COLORADO GEOLOGICAL SURVEY

September 15, 2026

**Subject: Honor Charter School D-49 Site Development Plan, Colorado Springs
El Paso County, CO; El Paso File No: PPR2615; CGS Unique No. EP-27-0008**

**FIELD EXPLORATION PLAN
(AERIAL)**

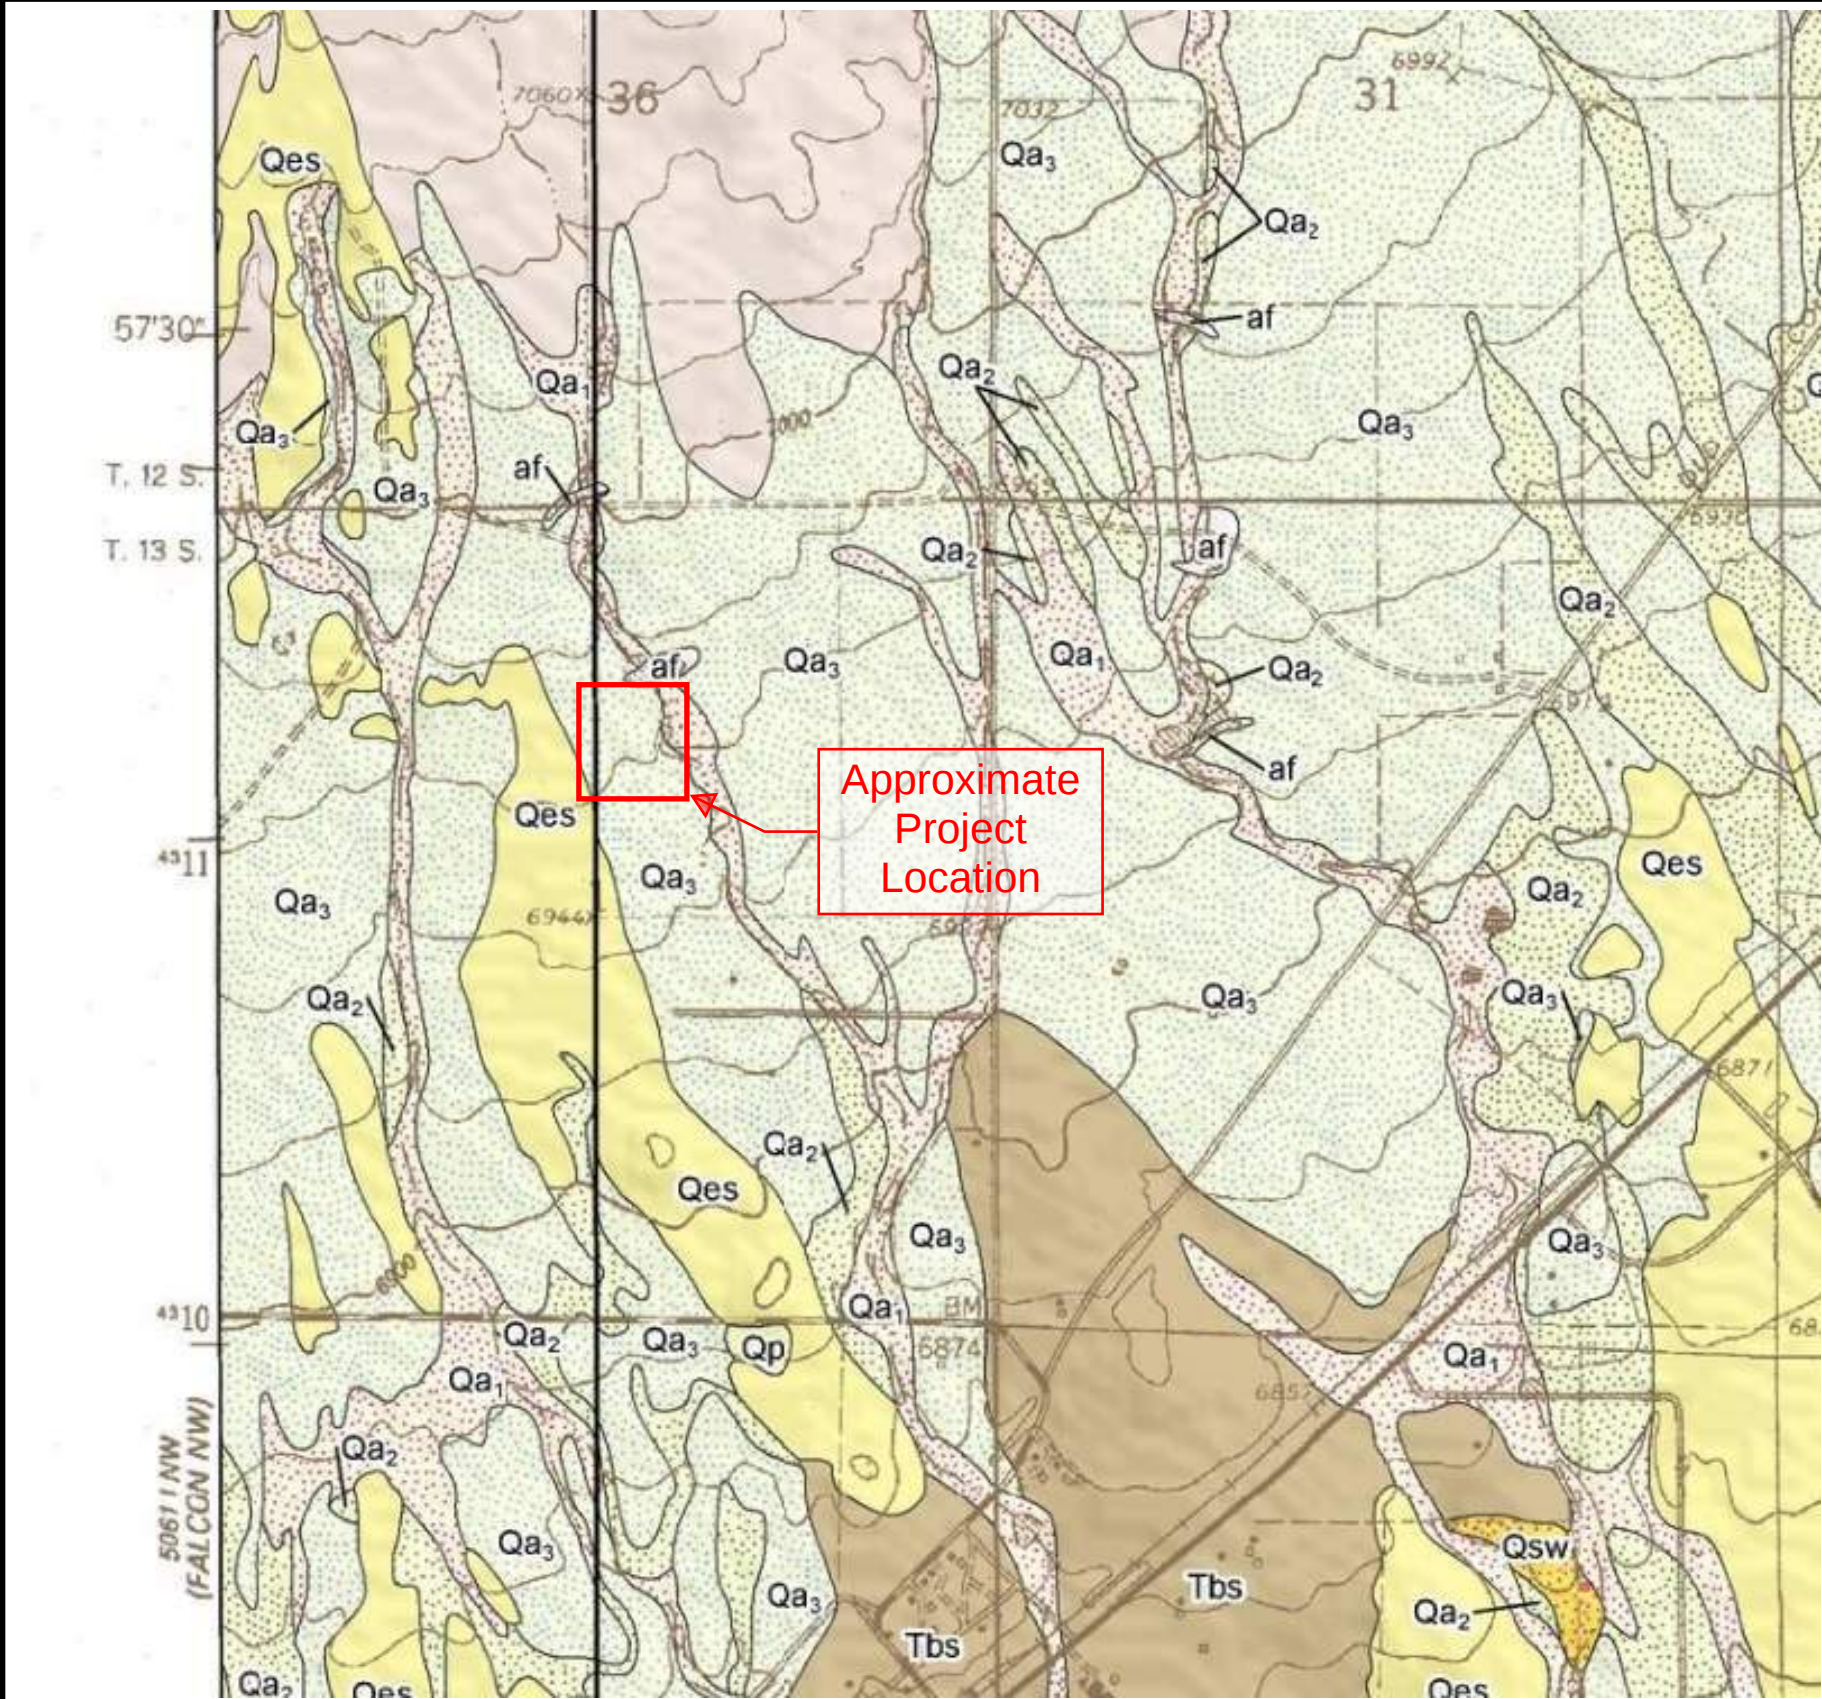
1. **Engineering geology map.** Consistent with El Paso County geology and soils report requirements, a site-specific engineering geology map should be provided depicting the relevant geologic conditions and hazards at the site.
2. **Project specifications.** Section 00 3100, 1.01.C of the Project Specifications and applicable notes on the Site Development Plan should be revised to reference the March 30, 2026 revised Geotechnical Evaluation Report.
3. **Shallow groundwater.** Vivid states in its geotechnical evaluation (page 8), "The main geotechnical issue is the presence of shallow groundwater at the site." Groundwater was encountered at depths of approximately 5.5 to 9 feet below existing grade, and the seasonal high groundwater level has not been established. Vivid recommends a foundation perimeter drain connected to a gravity outlet or

4. **Loose/compressible soils and settlement.** The investigation encountered approximately 7 to 14 feet of sandy overburden ranging from very loose to medium dense, and the report identifies localized loose, compressible overburden soils as a principal geotechnical concern. The proposed grading includes approximately 2.5 to 5 feet of fill beneath the school building pad. CGS recommends that the potential for total and differential settlement of the very loose to loose soils under the proposed fill and building loads be evaluated and that specific mitigation criteria be provided, including the depth and extent of removal and recompaction, overexcavation, or other ground improvement, as appropriate.

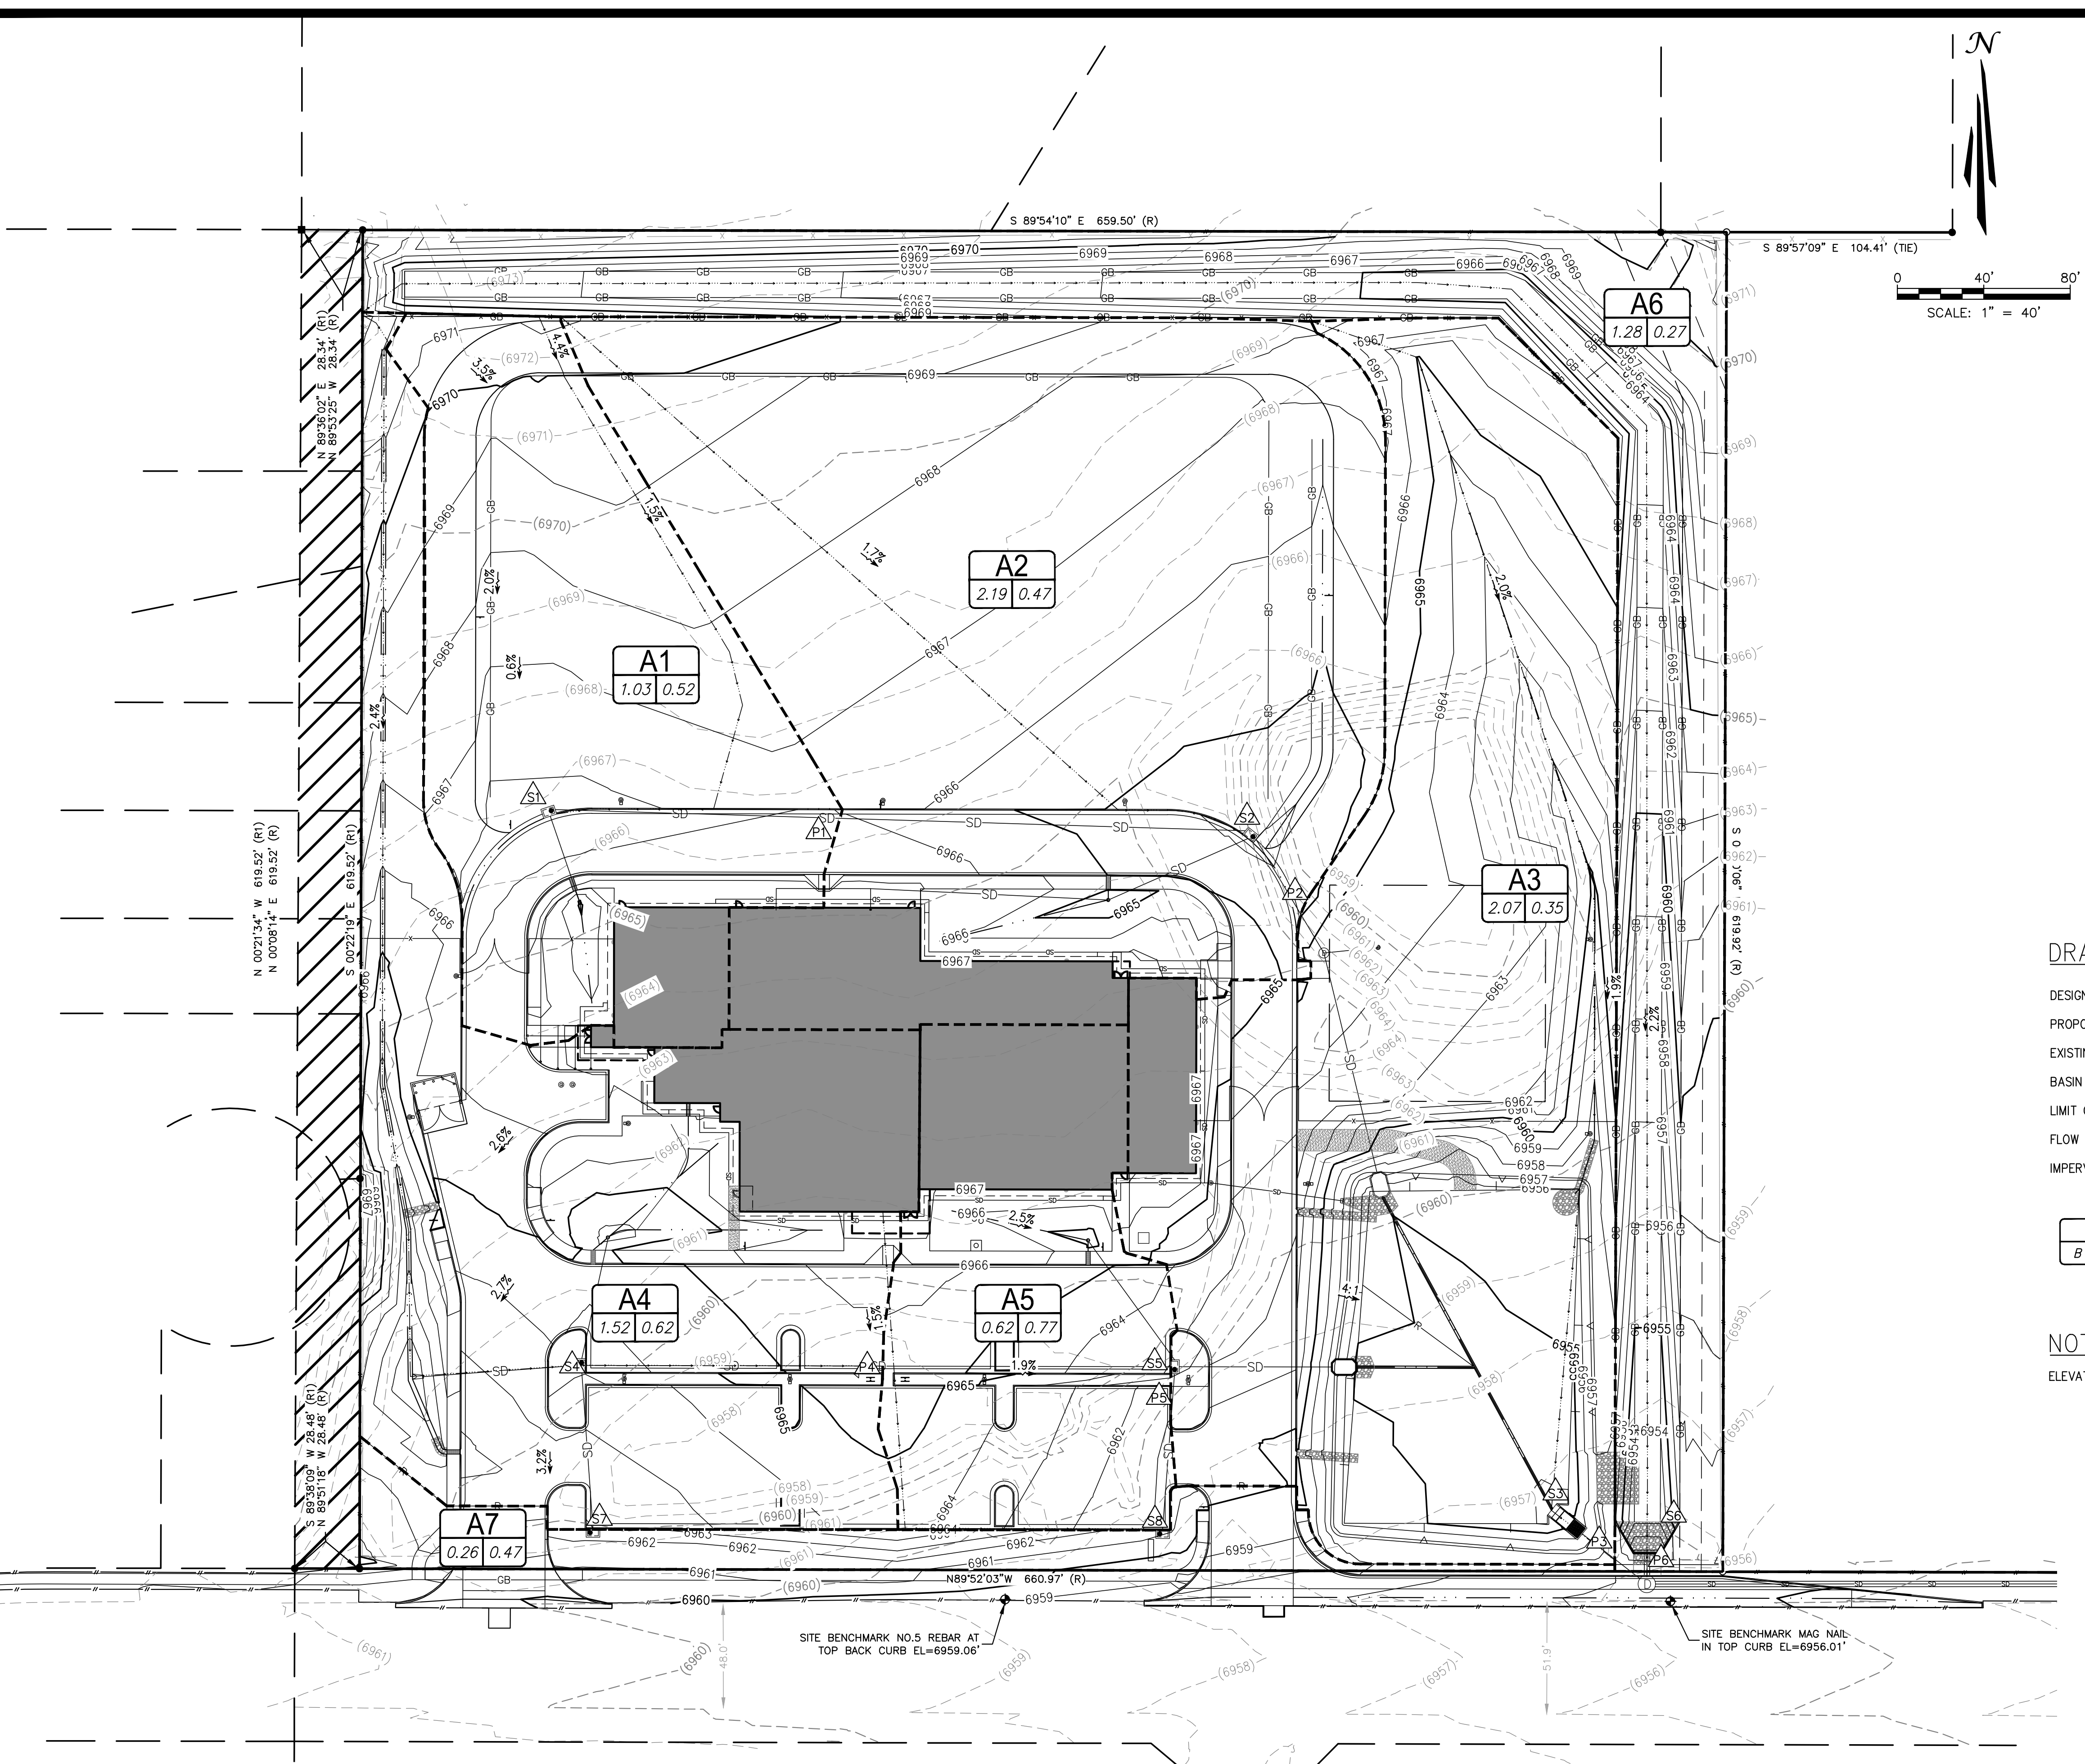
sump to address groundwater at the proposed building; however, the potential interaction between shallow groundwater and the proposed detention pond has not been addressed. CGS recommends that the seasonal high groundwater condition be evaluated relative to the proposed detention pond and that the project plans clearly depict the recommended foundation drainage system and its discharge.
